Ribble Valley Borough Council  
Housing & Development Control

Application no: **3/2021/0130**

Address: **67 Hillcrest Road Langho BB6 8EN**

Proposal: **Regularisation of erection of 1.8m high garden fence to boundary**

Proposed fence at :	
<b>67 Hillcrest Road Langho BB6 8EN</b>	
CLIENT:	Mr D Houlker
DATE:	December 2020
SCALE:	1:50 @ A1
DWG No:	Fence Elevations
L.A:	
AMENDMENTS:	DATE:
<b>ENTWISTLE DESIGN SERVICES</b>

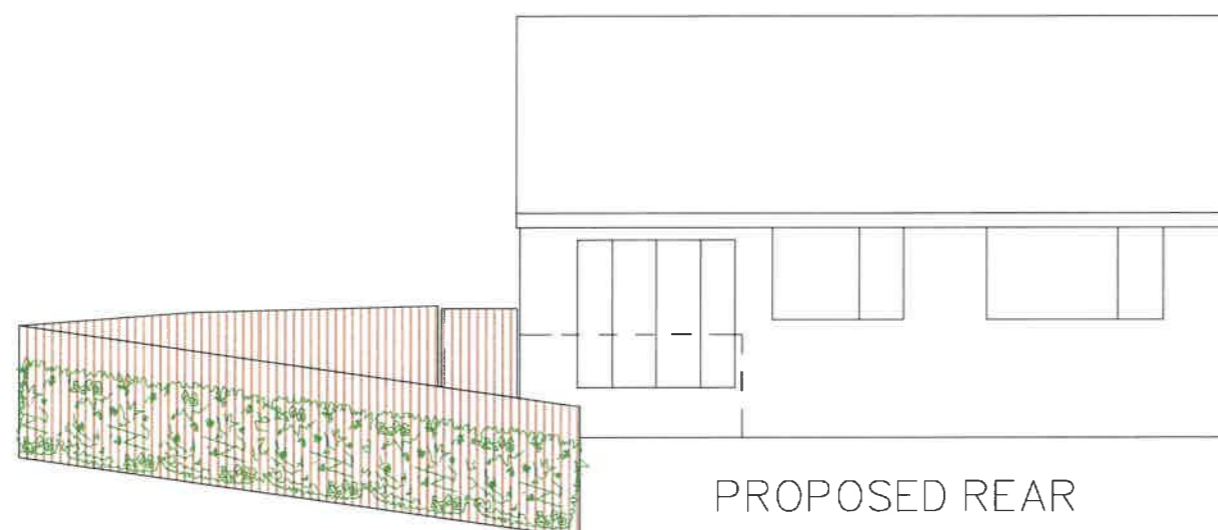
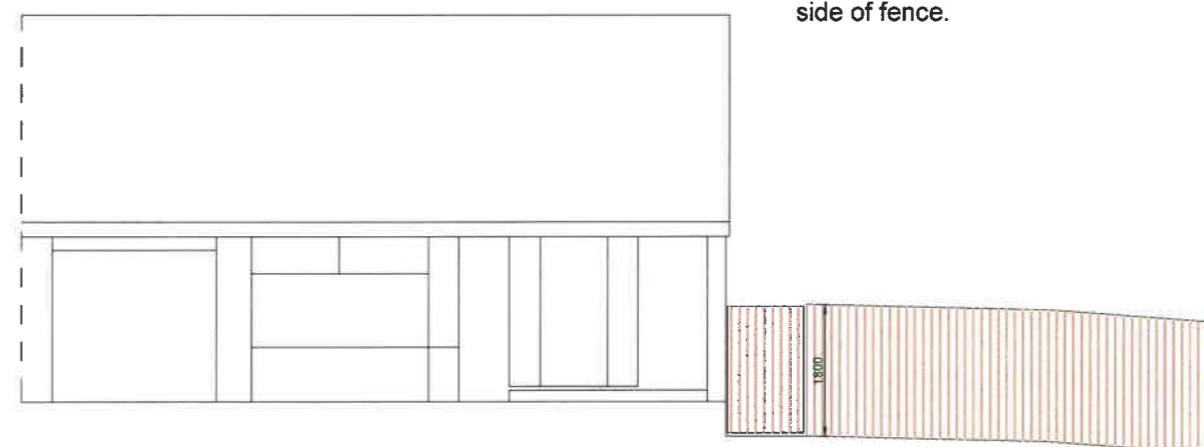
The proposal seeks regularisation of the erection of a 1.8m high garden fence to the boundary of the property and includes the creation of a further two off-street parking spaces. There have been no details provided for the new driveway and the local highway authority therefore requires details of the dimensions and materials used as well as visibility splays. The driveway will require a vehicular dropped crossing which will need to be installed by Lancashire County Council under section 184 of the Highways Act 1980.

I ask that more information is provided as requested above and that the plans are revised to reflect the rectification of the above raised highway concerns.
